Cherwell District Council  
Planning & Development Services  
Bodicote House White Post Road  
Bodicote  
Banbury  
OX15 4AA

**Our ref:** WA/2022/129863/01-L01  
**Your ref:** 22/01144/F  
**Date:** 11 August 2022

**Full Planning Application For The Erection Of A New High Quality Combined Research, Development And Production Facility Comprising Of Class B2 Floorspace And Ancillary Office Floorspace With Associated Infrastructure Including: Formation Of Signal-Controlled Vehicular Access To The A41 And Repositioning Of Existing Bus Stops; Ancillary Workshops; Staff Gym And Canteen; Security Gate House; A Building For Use As An Energy Centre (Details Of The Energy Generation Reserved For Future Approval); Loading Bays; Service Yard; Waste Management Area; External Plant; Vehicle Parking; Landscaping Including Permanent Landscaped Mounds; Sustainable Drainage Details; Together With The Demolition Of Existing Agricultural Buildings Within The Red Line Boundary; And The Realignment Of An Existing Watercourse.**

**OS Parcel 5700 South West Of Grange Farm, Street Through Little Chesterton, Chesterton**

PLAN SHOWING PROPOSED CULVERTED WATERCOURSE UNDER DEVELOPMENT ACCESS ROAD.

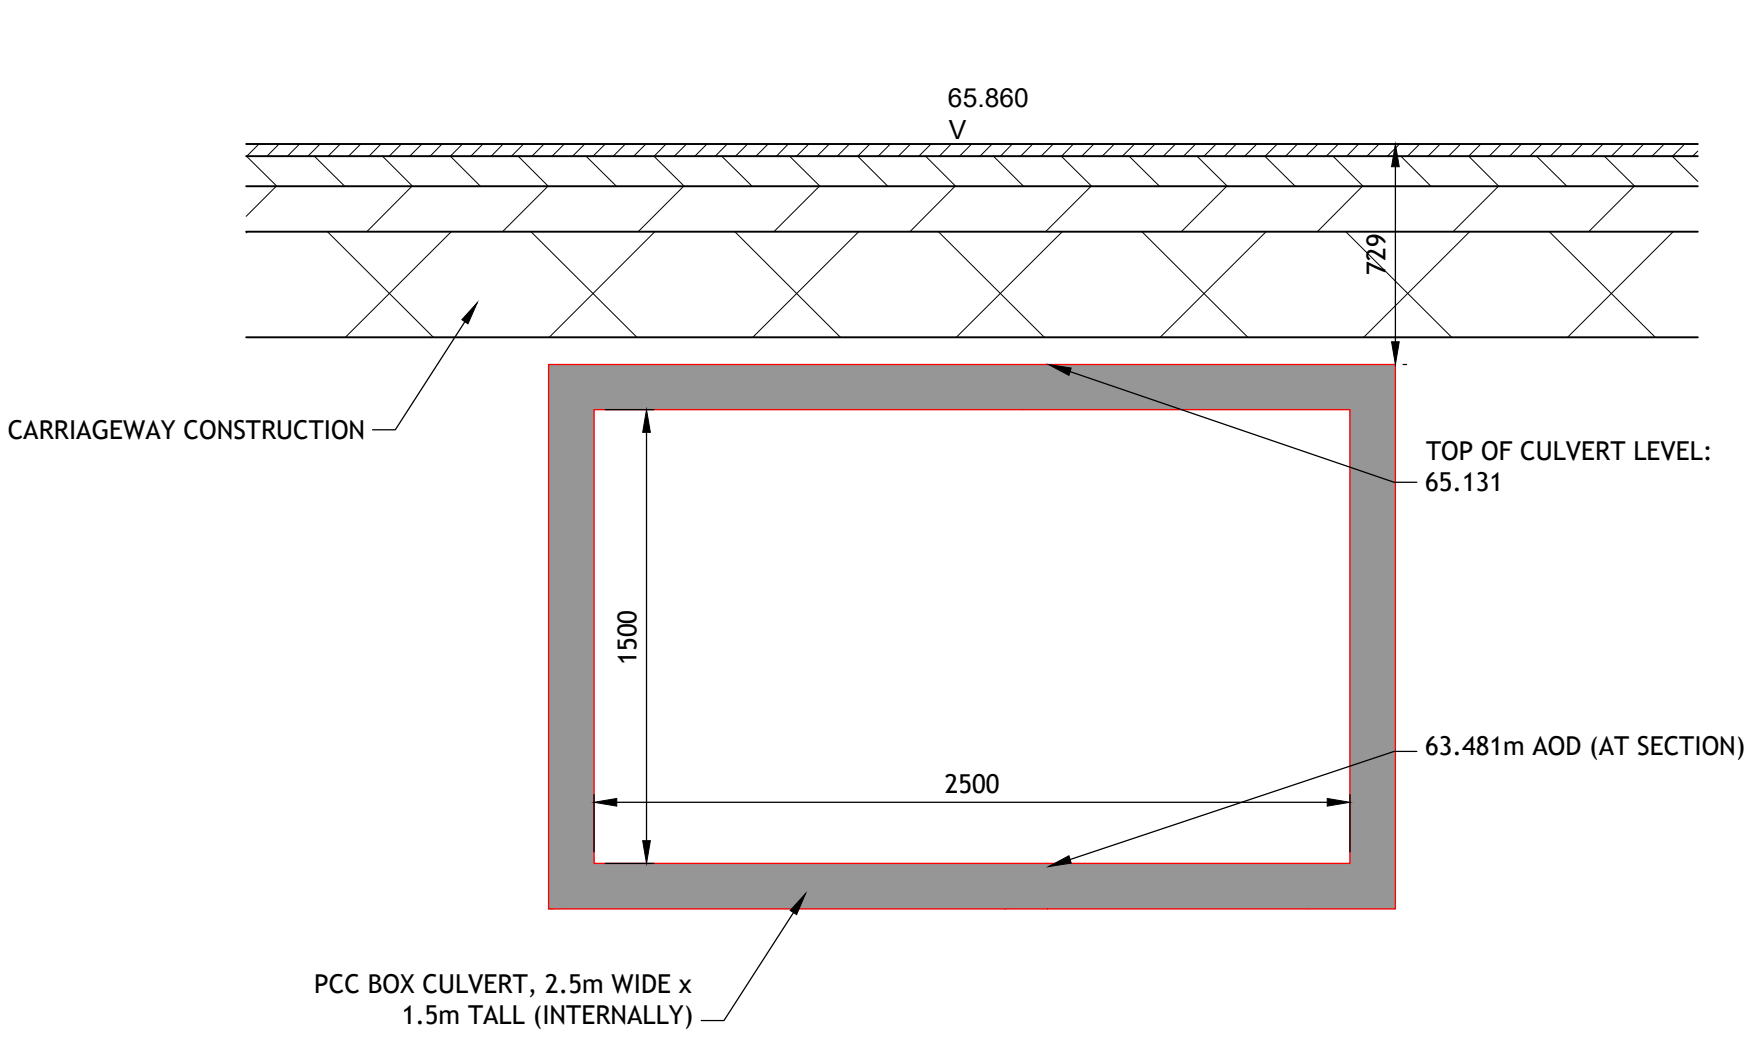
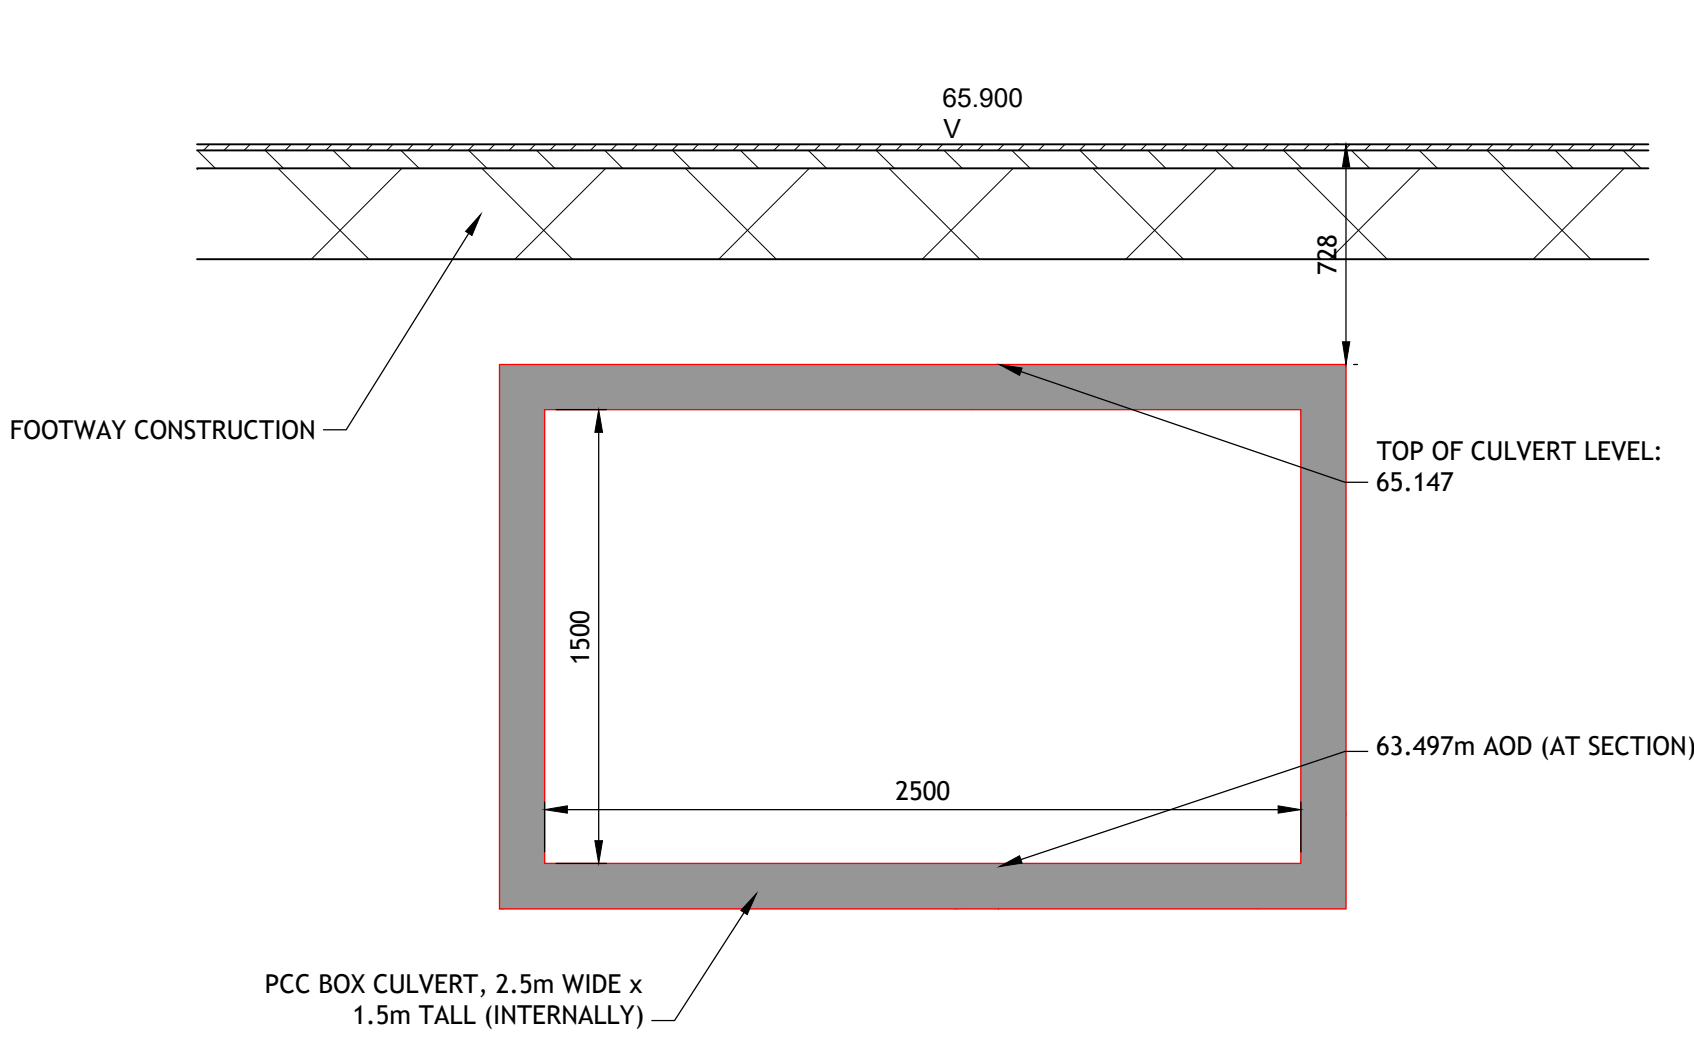
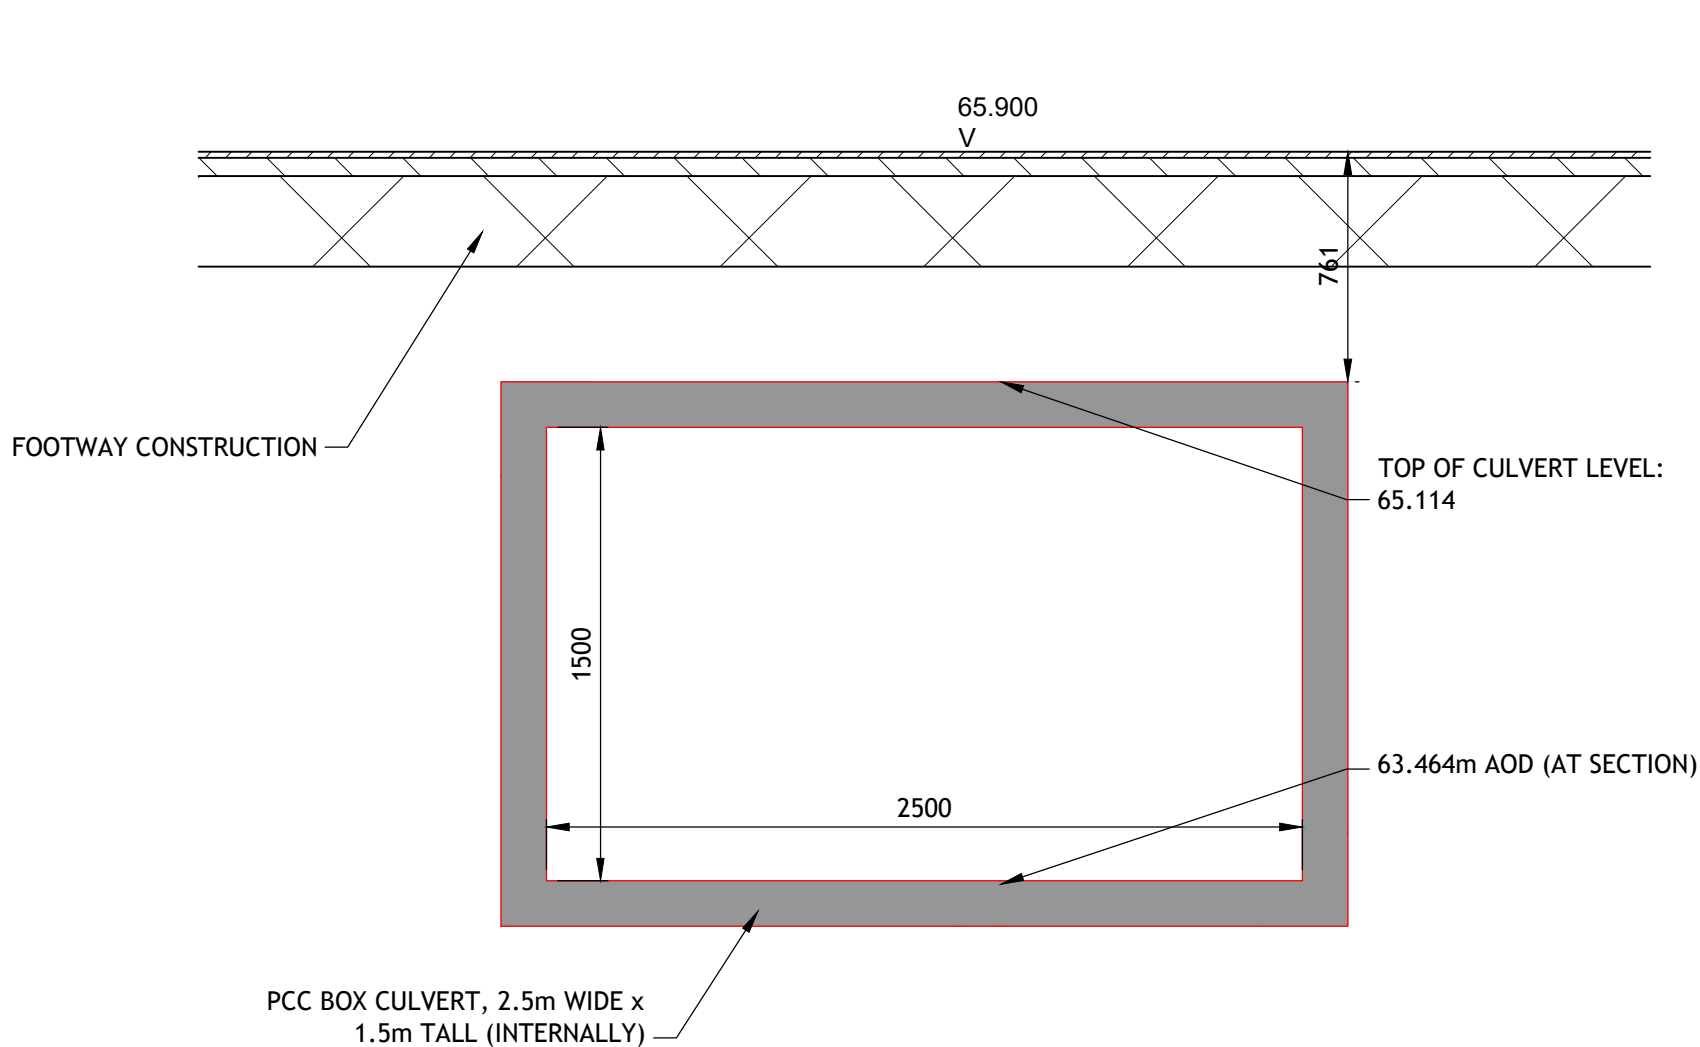
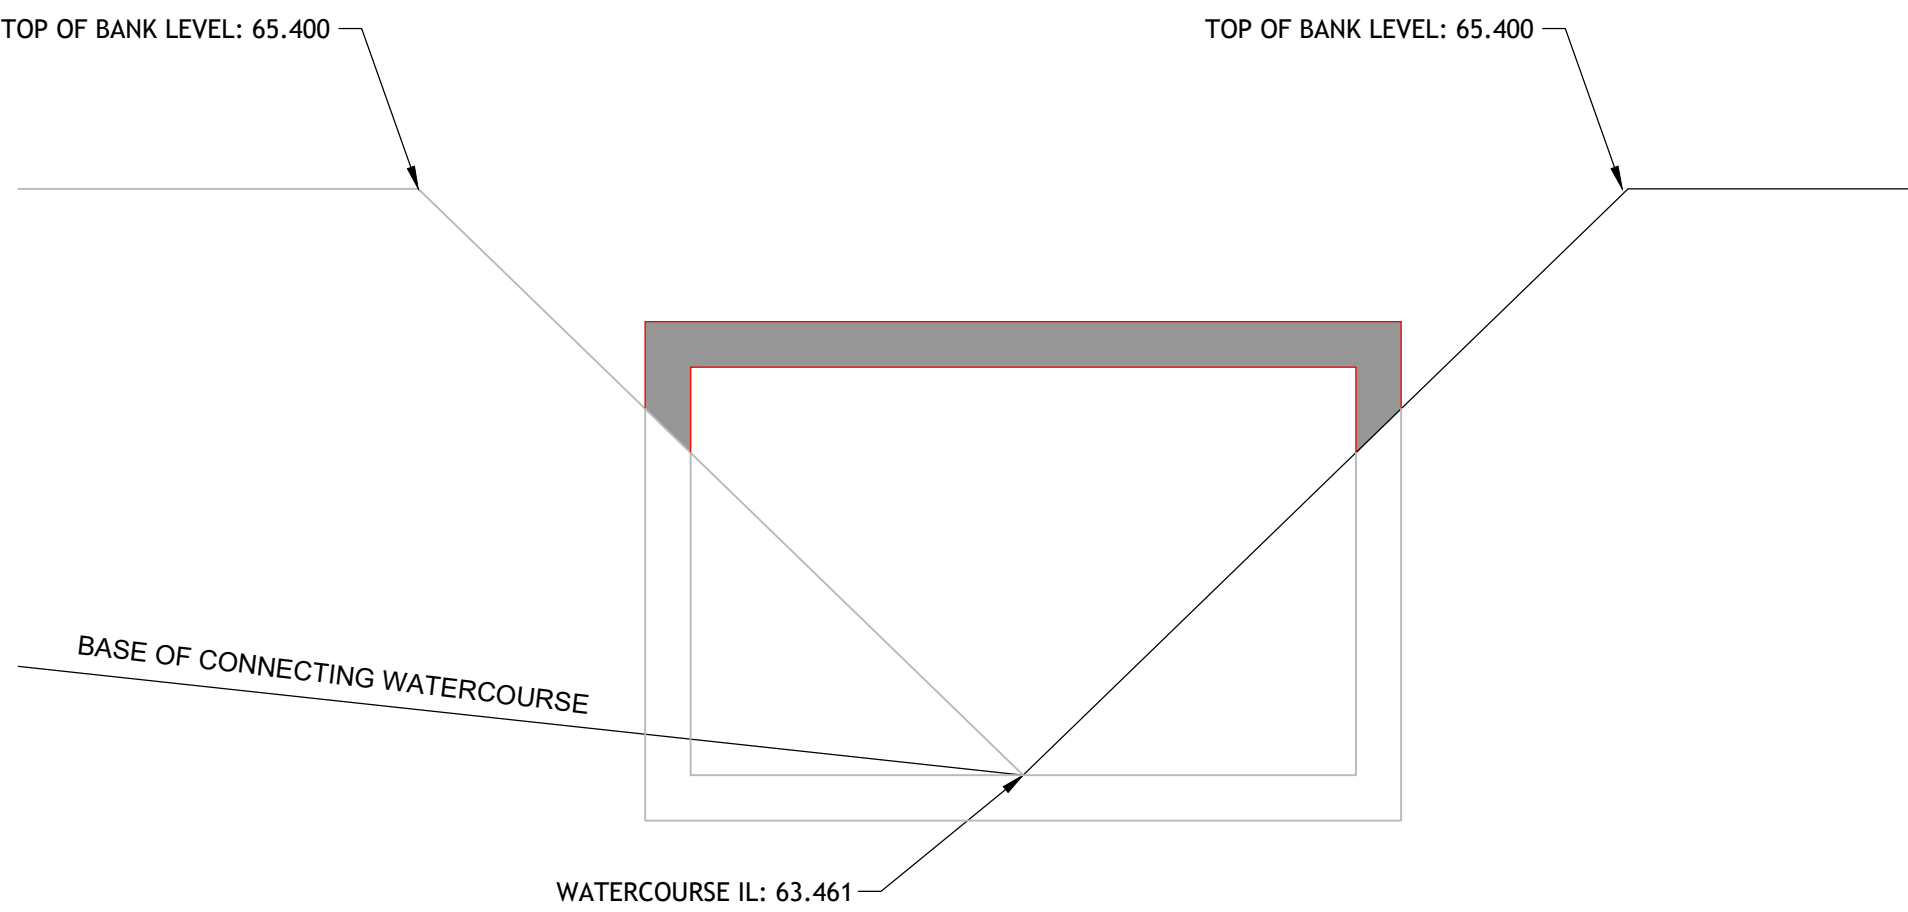
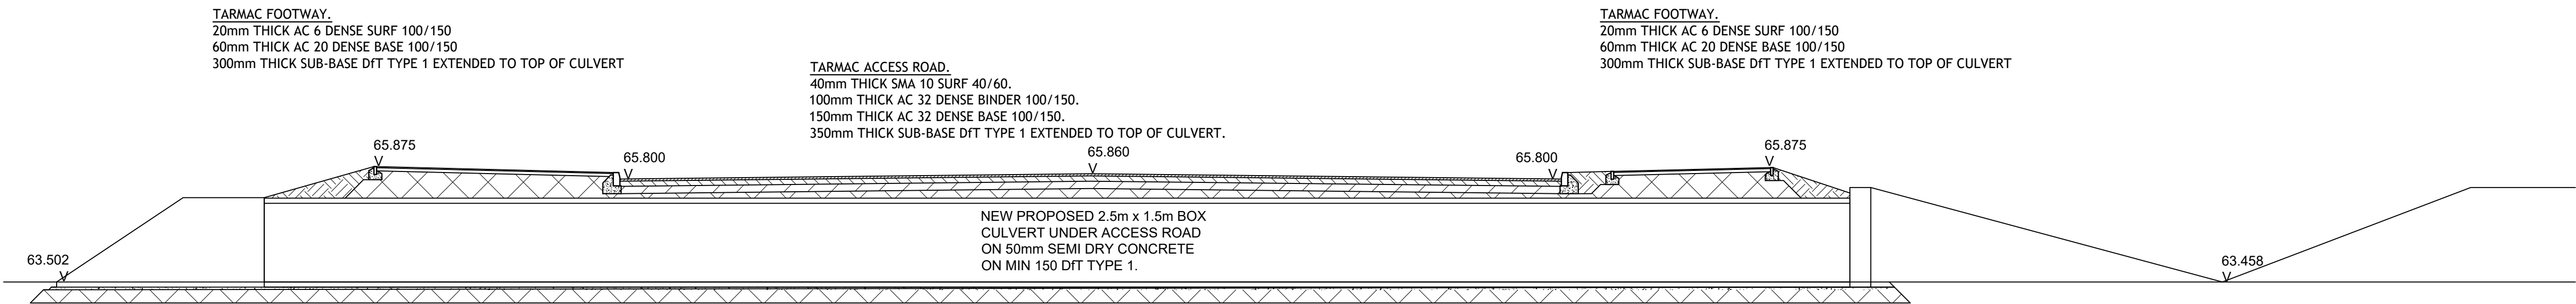
- i. Any effects on length due to re-alignment
  - ii. Additional culverting required to cross the access road
  - iii. Any further crossings required including the indicated footbridge
